A095004

Response to Comments Receive on 27th October 2017 from Carol Reynolds, Environmental Health for Arun District Council regarding planning application LU/278/17/RES – Discharge of Condition 36

WYG Responses in Blue

LYMINSTER BYPASS - SOUTH
NORTH LITTLEHAMPTON
PROPOSED ROAD ALIGNMENT AND
CONTOURS

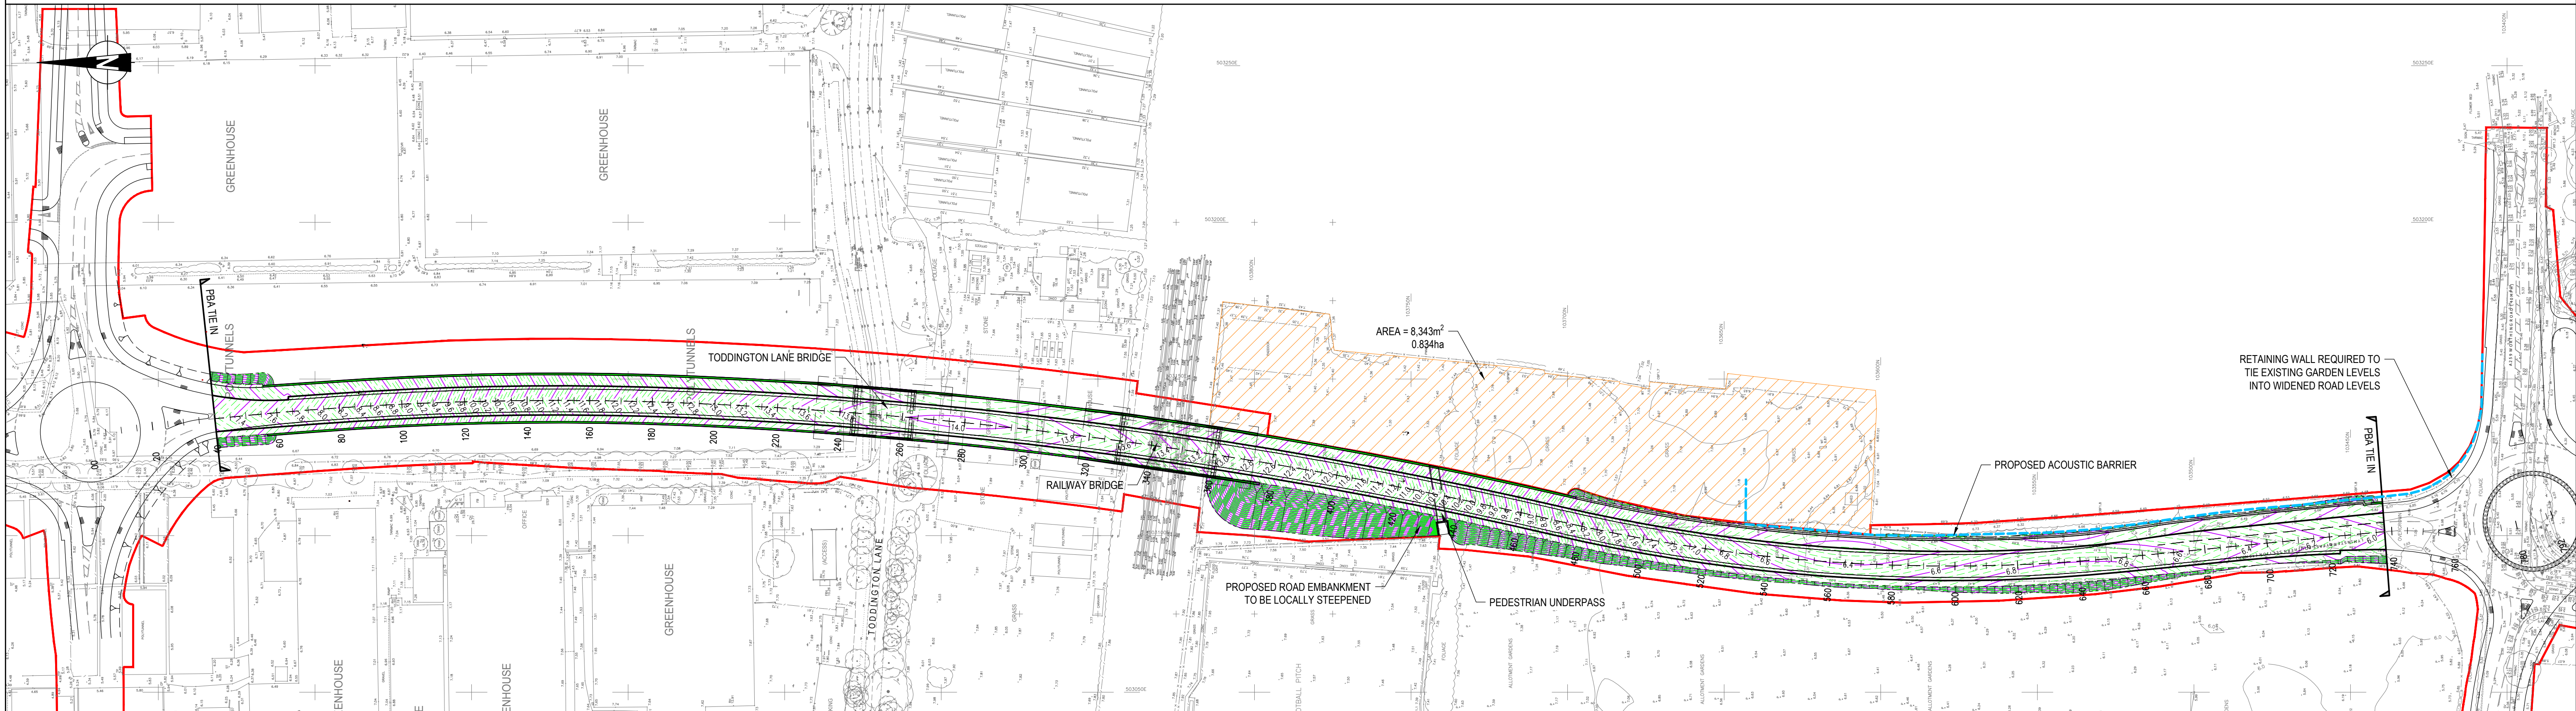
The Environmental Statement, Volume 1, February 2011, p 275, paragraph 10.6.2, 'Operational Noise' highlighted that properties bordering the east of the proposed Lyminster Bypass at Toddington Park were considered likely to require noise mitigation during the operational phase of this new road, namely a 2m minimum height acoustic timber barrier. That Noise Assessment prepared by WYG, August 2017 in respect of discharge of the above Condition proposes a 3m high acoustic barrier to extend around properties referred to as R1-R7 on Drawing Number SK02 and somewhat to the north of this; of given construction (Appendix C) which, it is stated, will achieve noise attenuation of up to 7.4dB (p18). Whereas this approximates to the location of Number 9 to 23 Toddington Park, please provide clarification as to which dwellings these references pertain.

The dwellings that will receive the 7.4dB reduction in noise levels as a result of the 3.0m barrier as stated in the report are TR6 which is representative of 14 Toddington Park and TR10 which is representative of 23 Toddington Park. Attached to this response is an updated version of SK02 showing these receptor locations.
